Your ref: SSD-50505215

Our ref: DOC24/699892

Subject: Bullawah Wind Farm (SSD-50505215)

ATTACHMENT A – BCS Assessment Summary for Bullawah Wind Farm Environmental Impact Statement (SSD-50505215)

- Flood depth (m)**
- 0.10 to 0.25 m
 - 0.25 to 0.50 m
 - 0.50 to 1.00 m
 - 1.00 to 1.50 m
 - 1.50 to 2.00 m
 - 2.00 to 2.50 m
 - 2.50 to 3.00 m
 - > 3.00 m

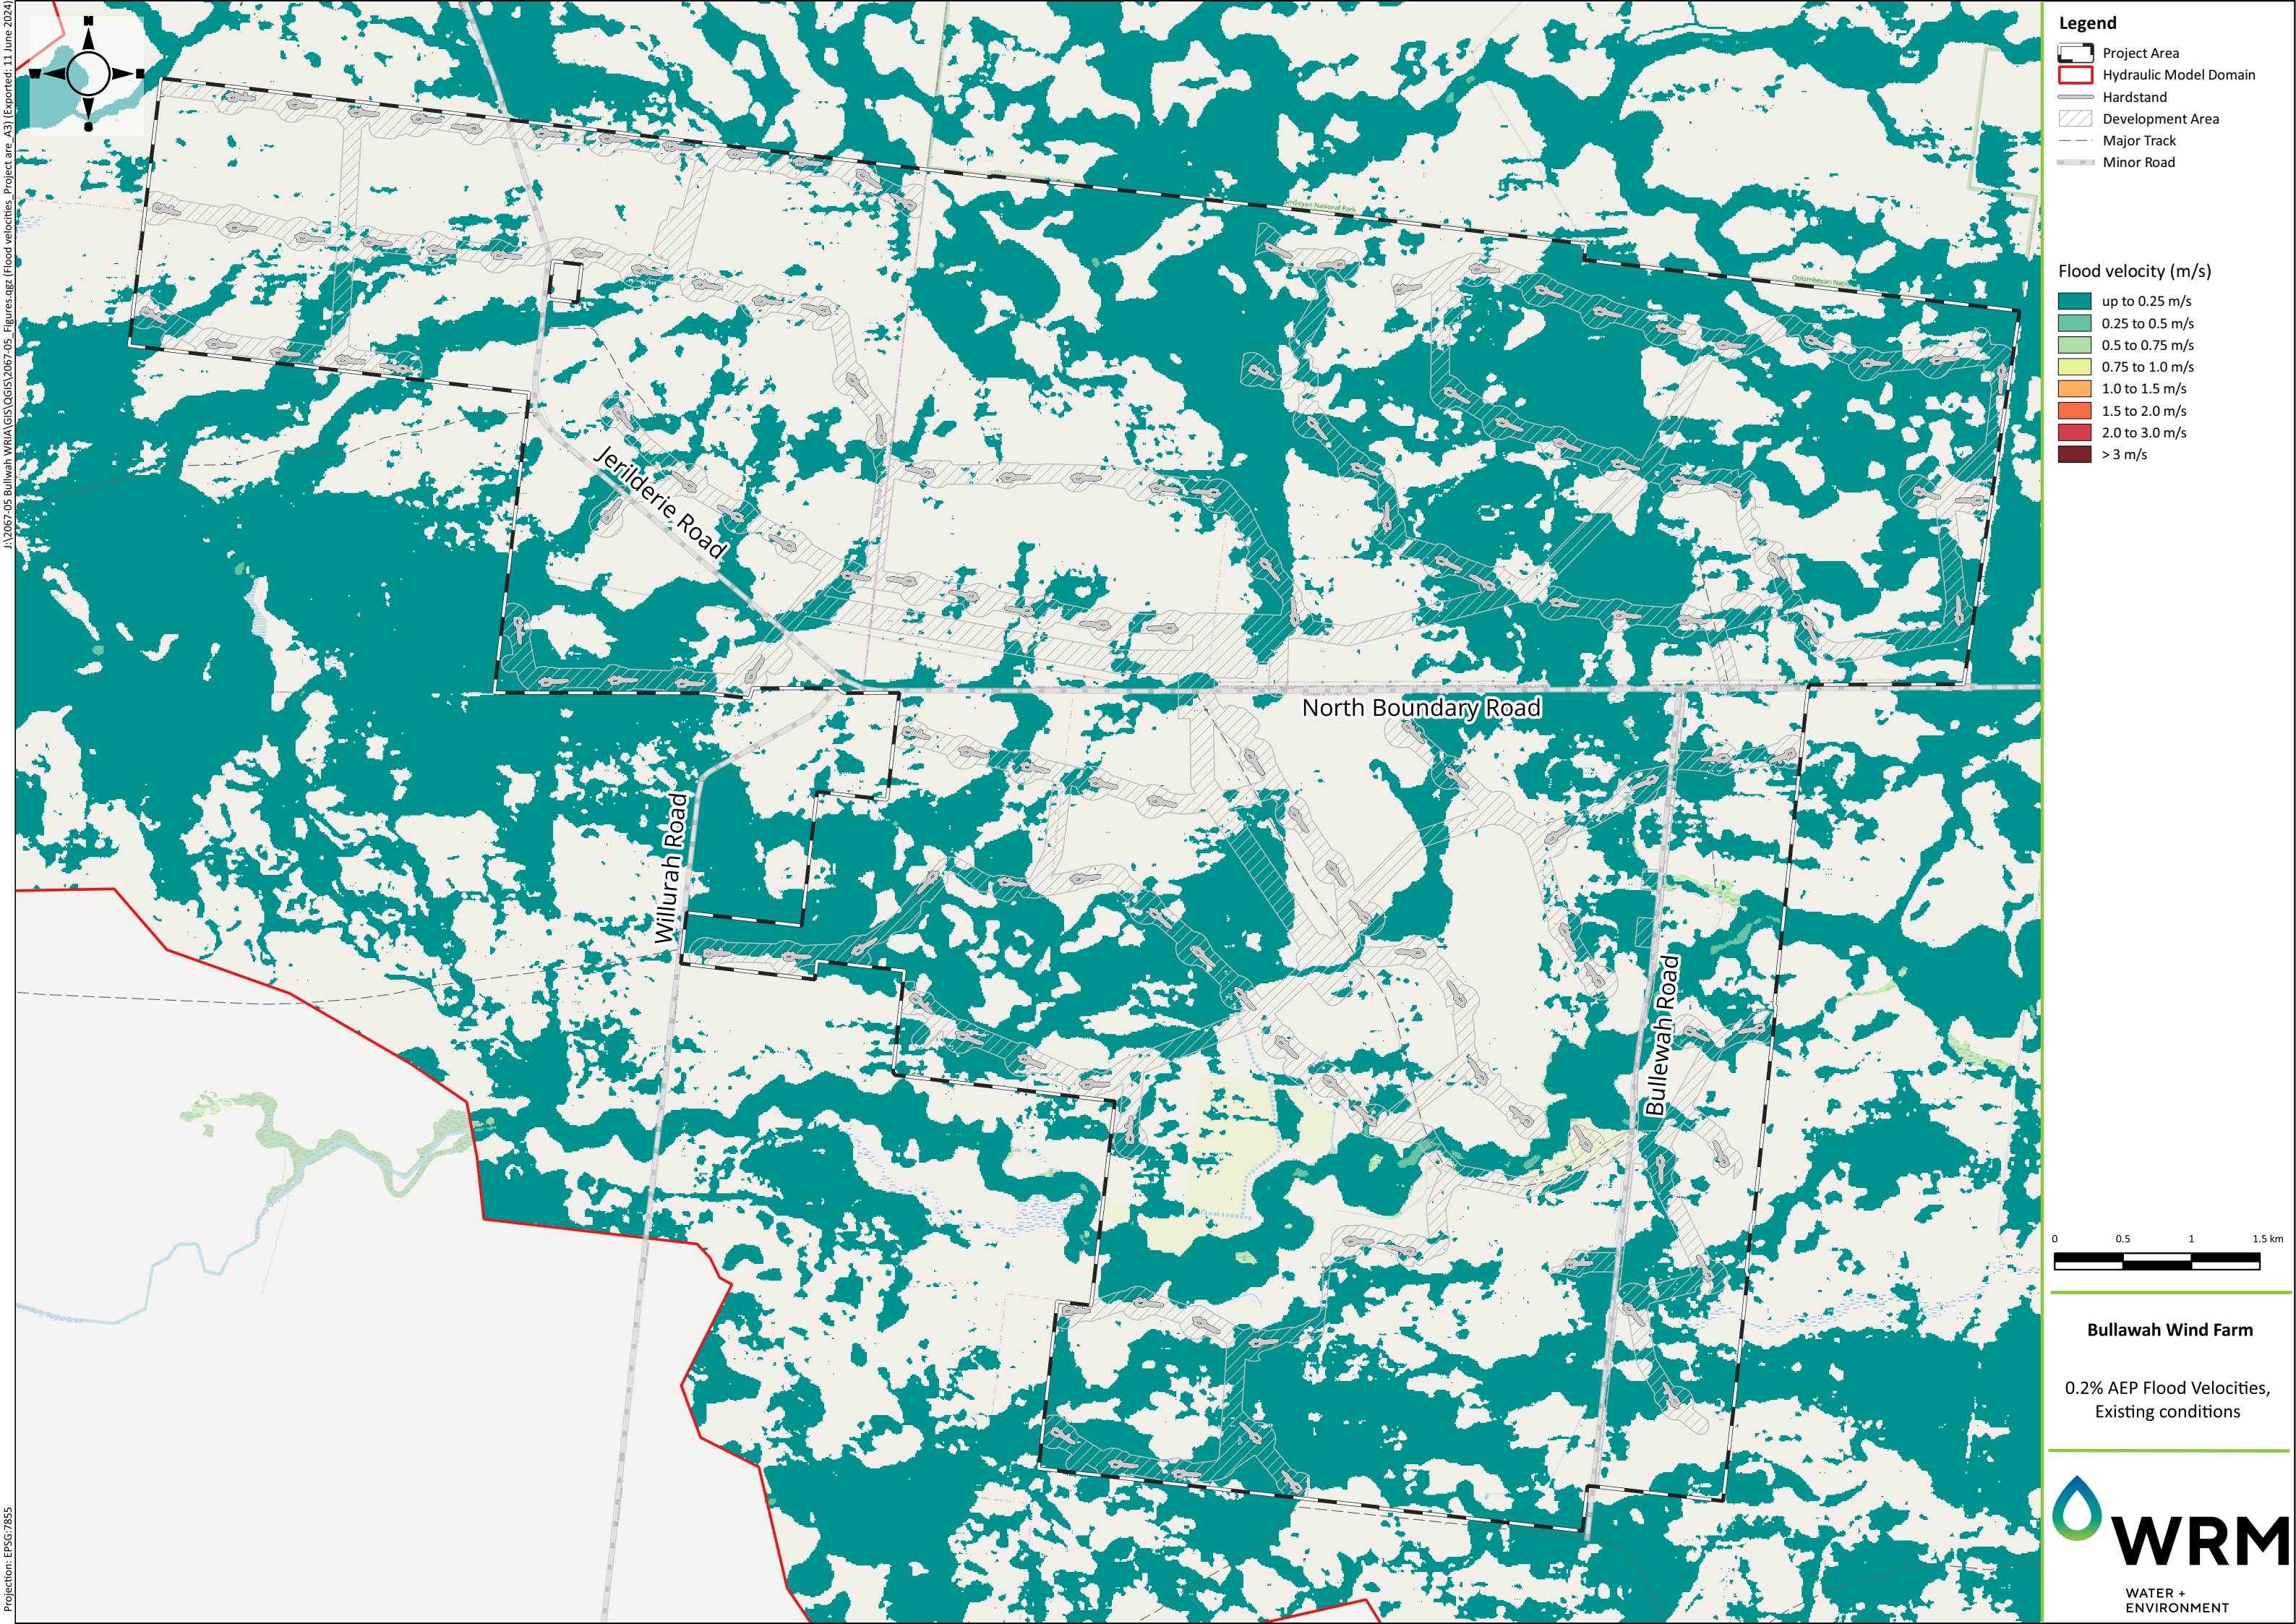
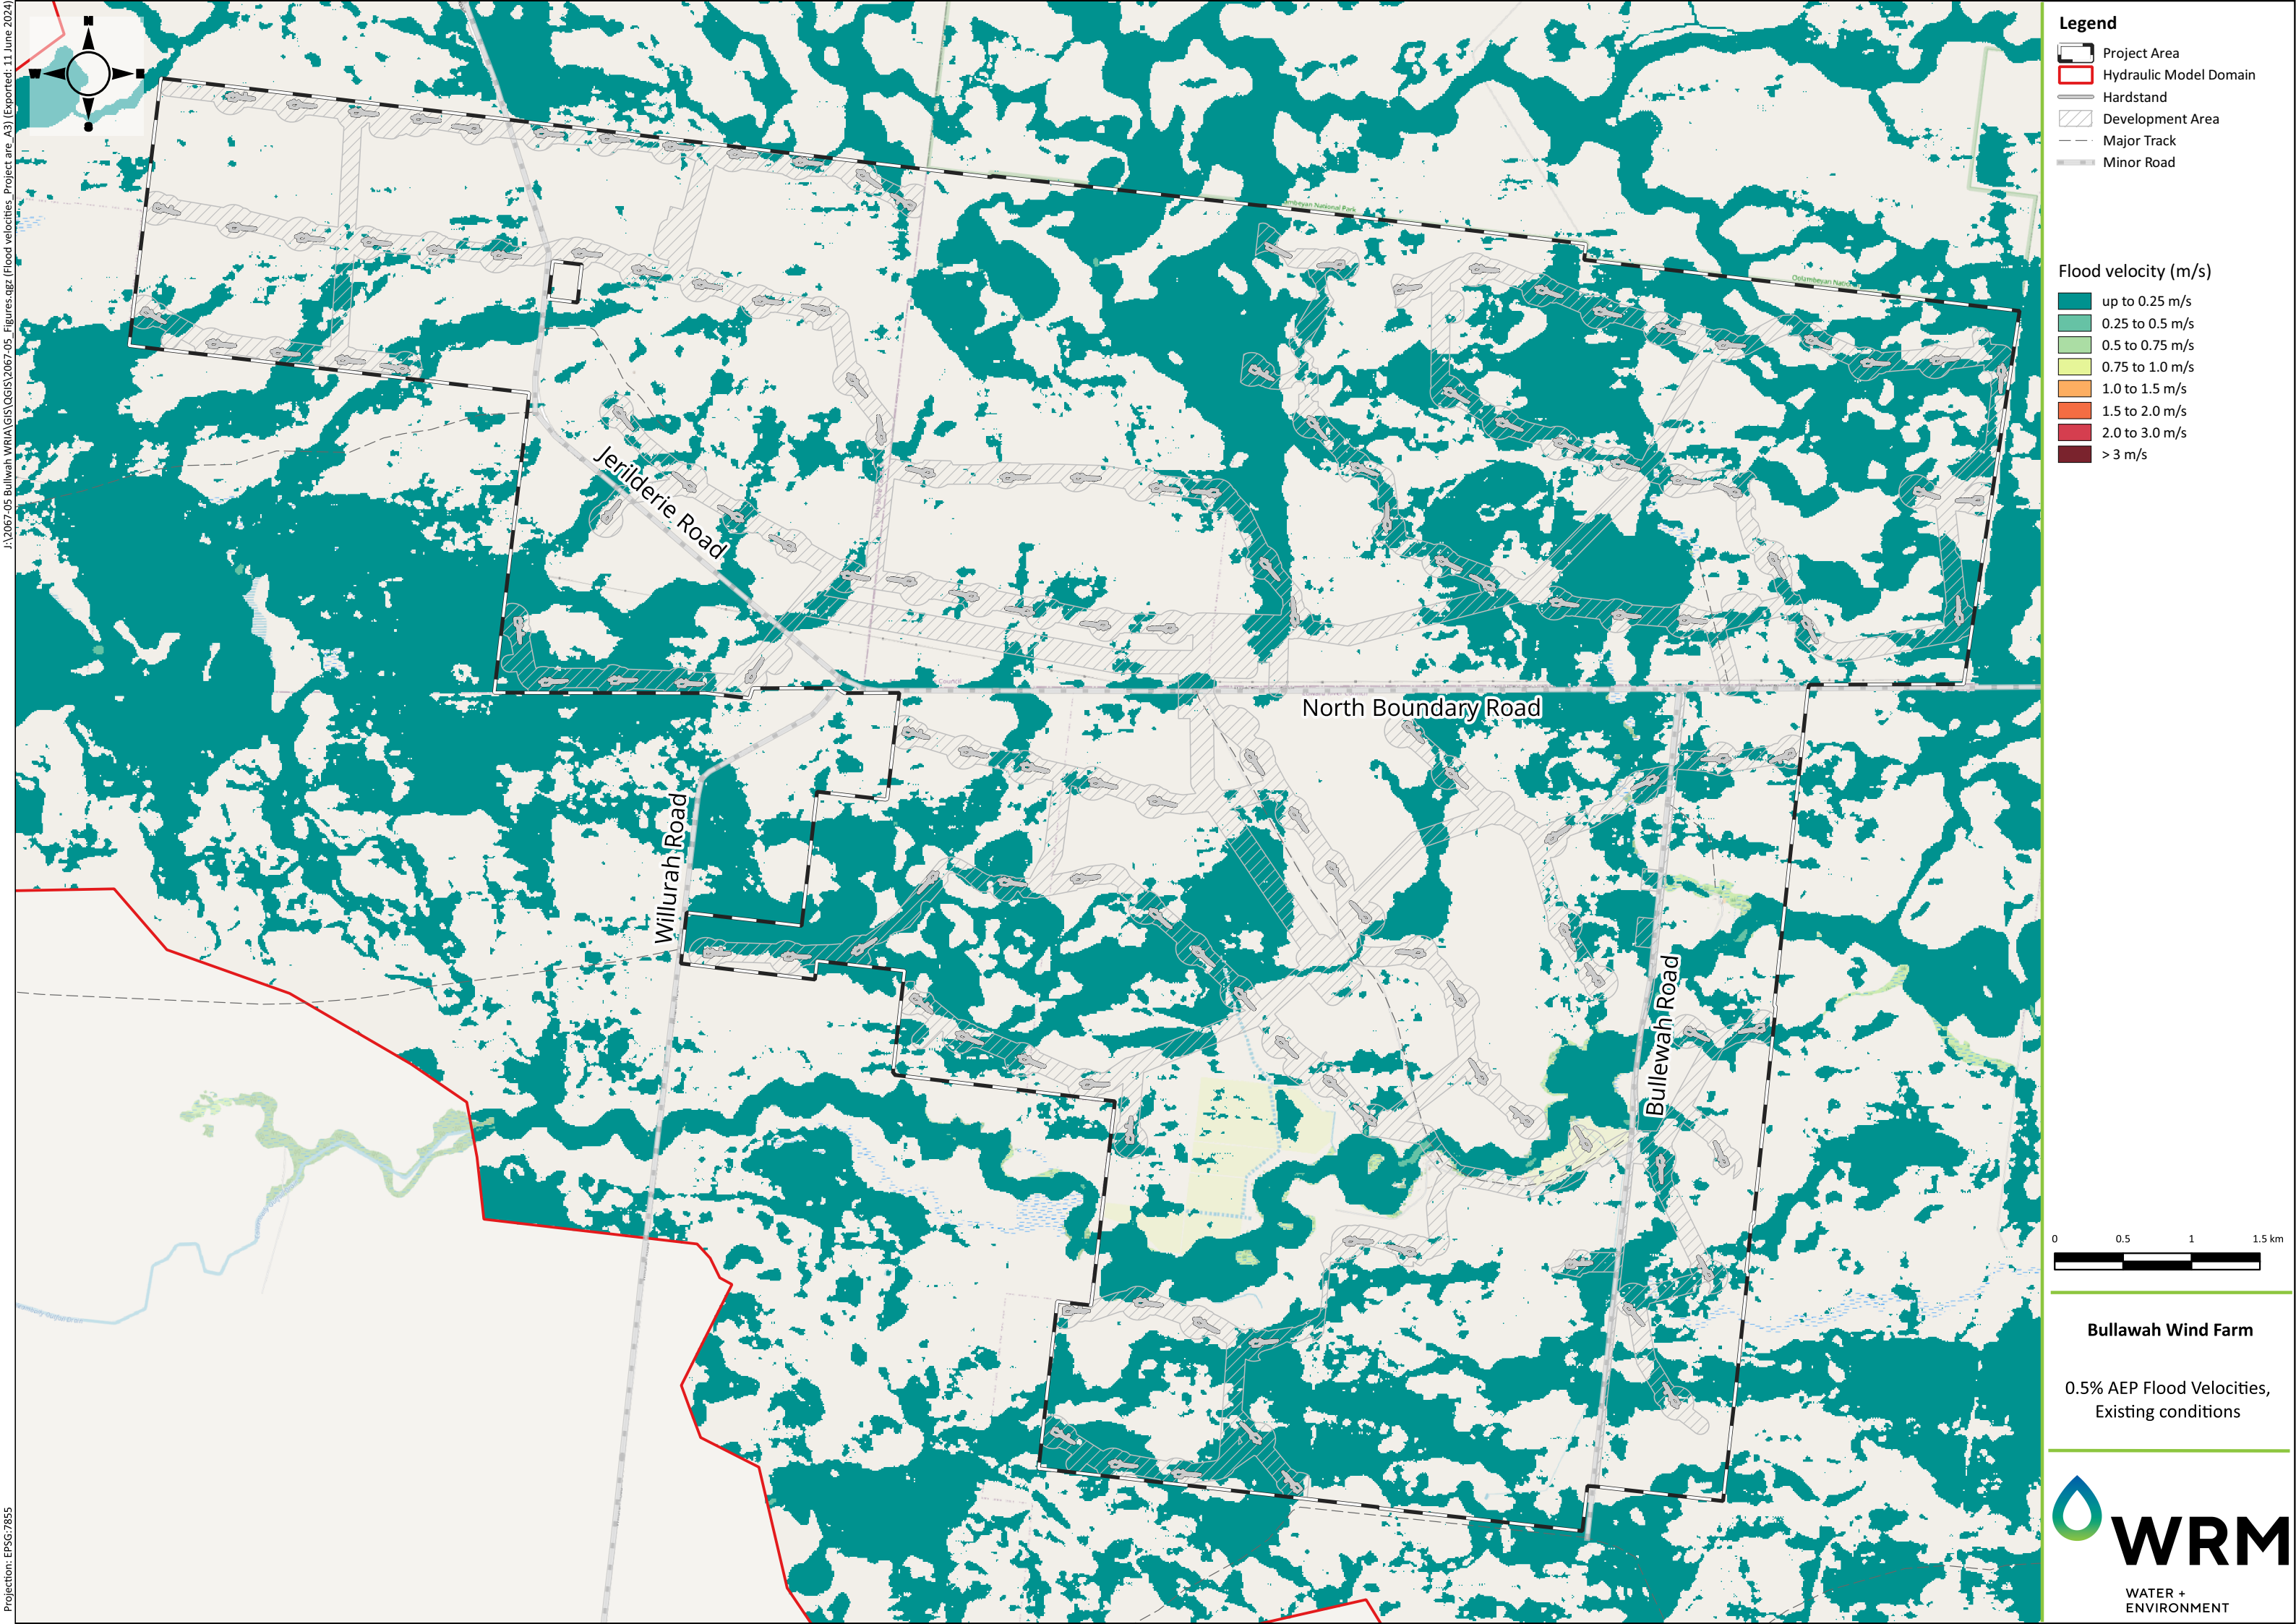
3. The flood modelling and mapping needs to include more detail of the project infrastructure to adequately inform the flood behaviour and flood risk assessment.

The Bullawah Wind Farm Project Water Resources Impact Assessment provides low-resolution mapping in its overview of the project. The mapping provides limited detail of the proposed project infrastructure, including ancillary works, in the landscape. As such, BCS is not able to determine the impact of the entire project on flood behaviour and the flood risks to the project infrastructure.

The proponent needs to complete clear and detailed mapping of sensitive and hazardous infrastructure, such as the temporary workers' accommodation, battery storage and multiple substations to allow appropriate flood risk assessment to be completed. BCS recommends that future hydraulic modelling is based on the detailed design for the project infrastructure, which will include all aspects of development, to ensure the impact of the project on flood behaviour and the flood risks to critical project infrastructure are adequately assessed.

- 3.1. Ensure future hydraulic models include the detailed design for the proposed project infrastructure to ensure the impact of the project on flood behaviour and the flood risks to critical infrastructure are adequately assessed.
